Submission for Job: #6010 SSD 6010 - One Residential Building (Student Accommodation) within Darling Drive Plot

Site: #2824 SICEEP Site, The Haymarket; Darling Drive, Sydney

SSD 6010 - One Residential Building (Student Accommodation) within Darling Drive Plot

SHADOW DIAGRAMS: PERSPECTIVE, SHOWING THE PEAK, WINTER SOLSTICE

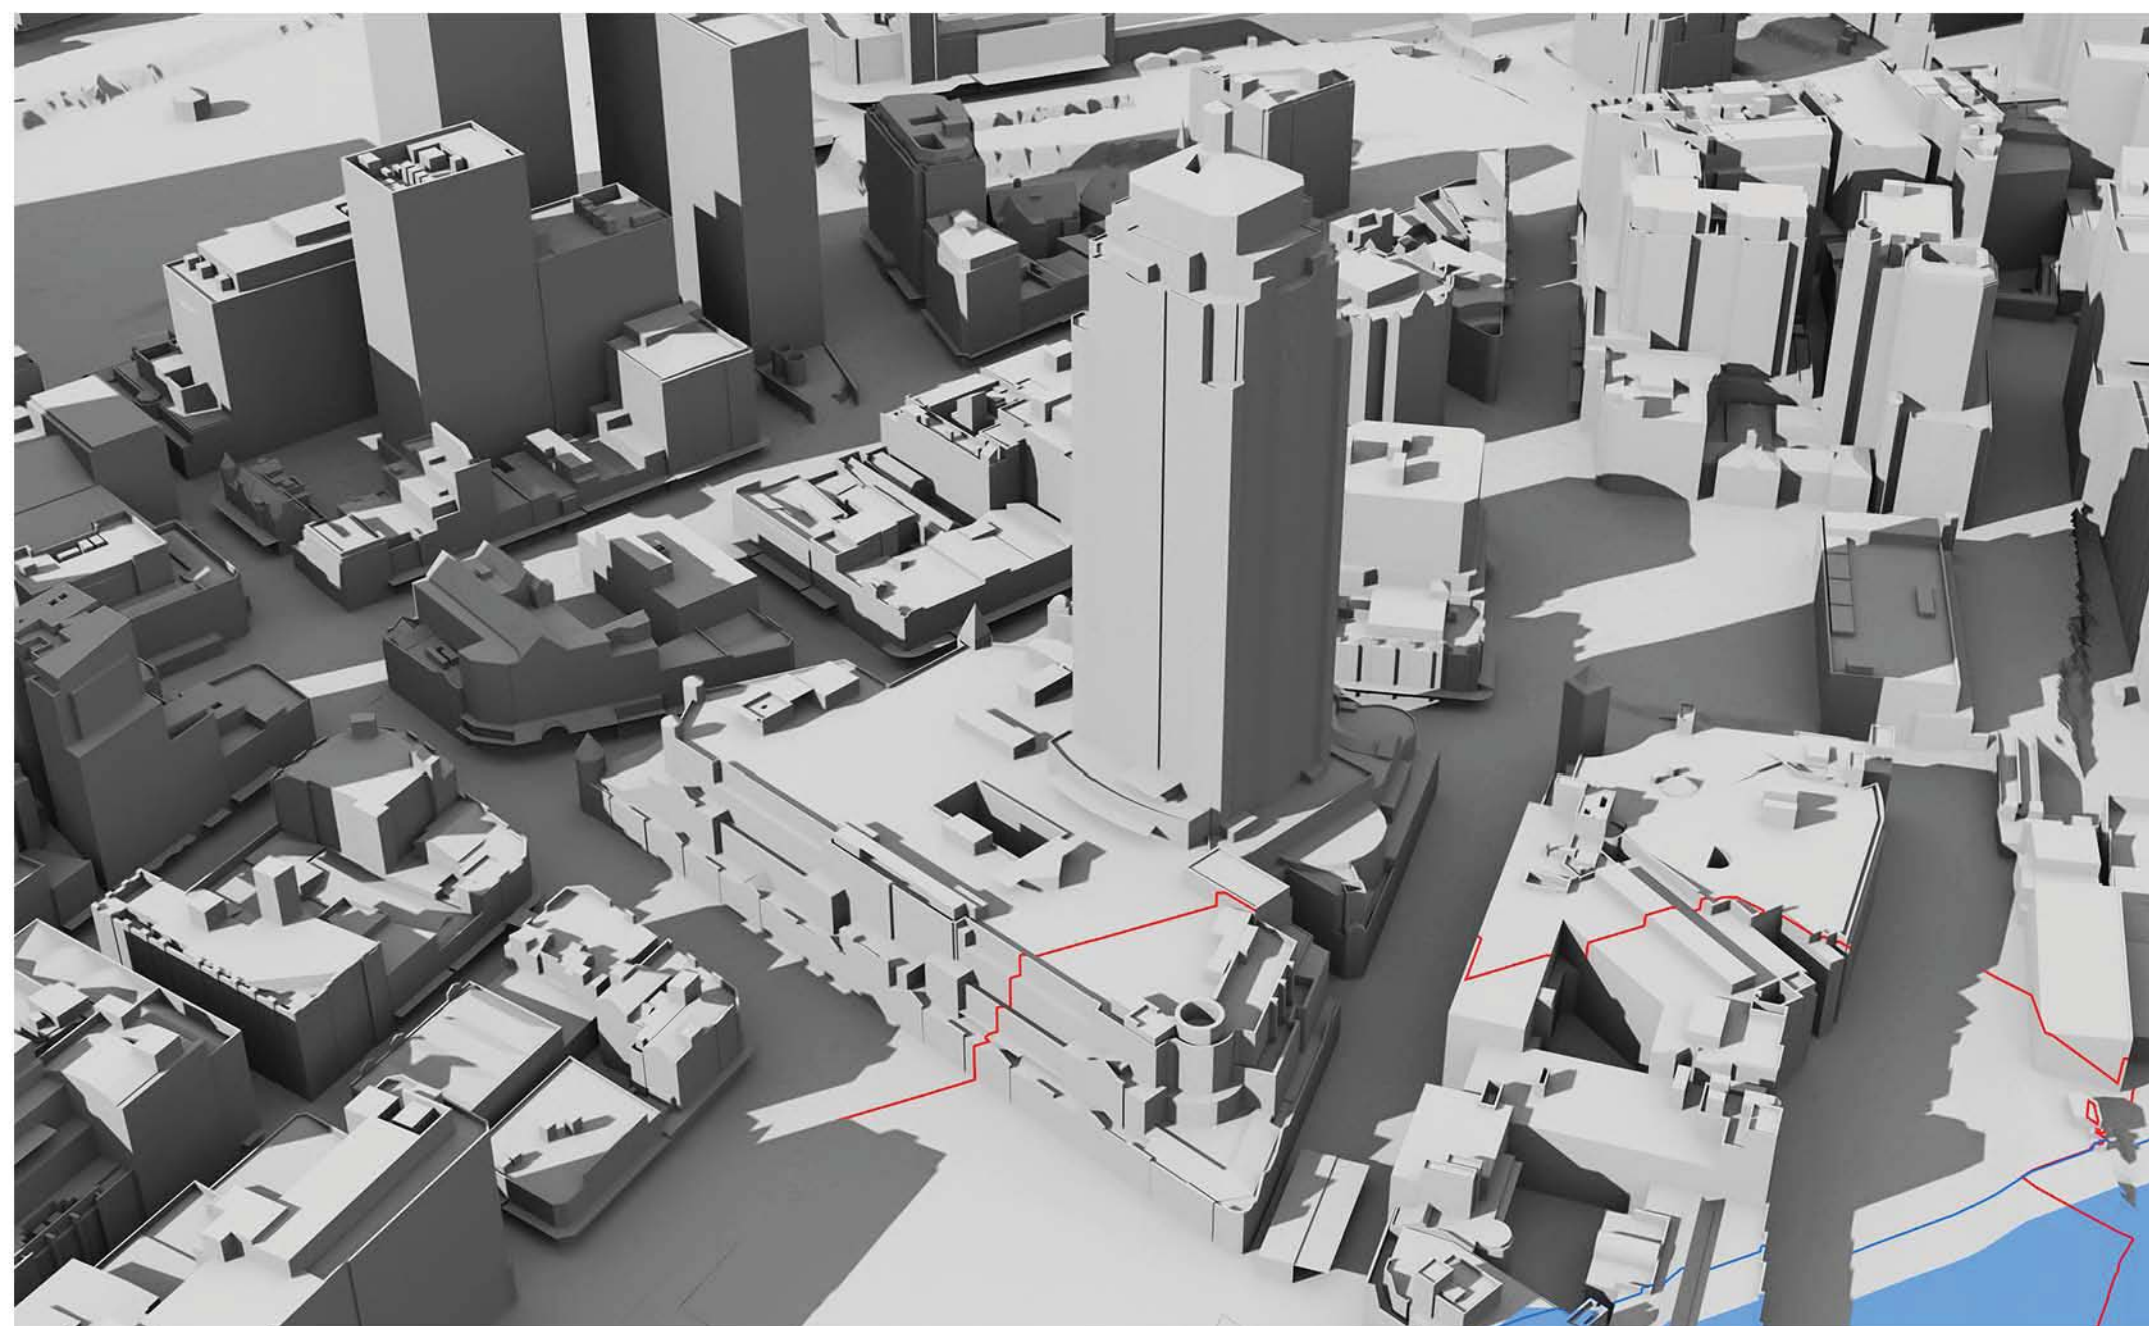
At 9am, 10am and 11am the west façade is totally in shadow due to other parts of The Peak building itself.

At 12pm there is still substantial existing shadowing on the west façade caused by the irregular shape of the west facade.

At 1pm the existing shadowing has been substantially removed, but not totally removed.

It can be concluded that some single aspect apartments on the west façade and some south-west dual aspect corner apartments currently receive less than 2 hours direct sunlight to habitable rooms and 50% of the private open space between 9am and 3pm on 21 June.

By 2pm the existing shadowing has been totally removed, but that is too late to achieve two hours of direct sunlight before 3pm.

At 9am, 10am and 11am the west façade is totally in shadow due to other parts of The Peak building itself.

At 12pm there is still substantial existing shadowing on the west façade caused by the irregular shape of the west facade.

At 1pm the existing shadowing has been substantially, although not entirely, removed. However, overshadowing of lower levels of the west façade by the concept proposal parameter plan shadows for the N,NE and SE plots has already started.

By 2pm the existing shadowing has been totally removed. However, overshadowing of the west façade by the SSDA4 and SSDA5 buildings has appeared and risen further up the west façade than the concept proposal parameter plan shadows for the N,NE and SE plots, which is still present.

At 3pm, the proponent states correctly that 45-45% of the western façade is overshadowed by the SSDA4 and SSDA5 buildings.

It can be concluded that, as a result of combination of the proposed development with existing shadowing of the west façade, some single aspect apartments on the west façade and the south-west dual aspect corner apartments which currently receive less than 2 hours direct sunlight to habitable rooms and 50% of the private open space between 9am and 3pm on 21 June will suffer additional overshadowing. It is beyond our skills to count the number of such apartments. We note that the proponent has made no attempt to do so.

Rather than counting the number of units which will not meet the DCP guidelines, the proponent attempts to trade-off direct sunlight at 4pm for lack of direct sunlight during the period 9am to 3pm. There is no provision in the DCP guidelines for such a trade-off.
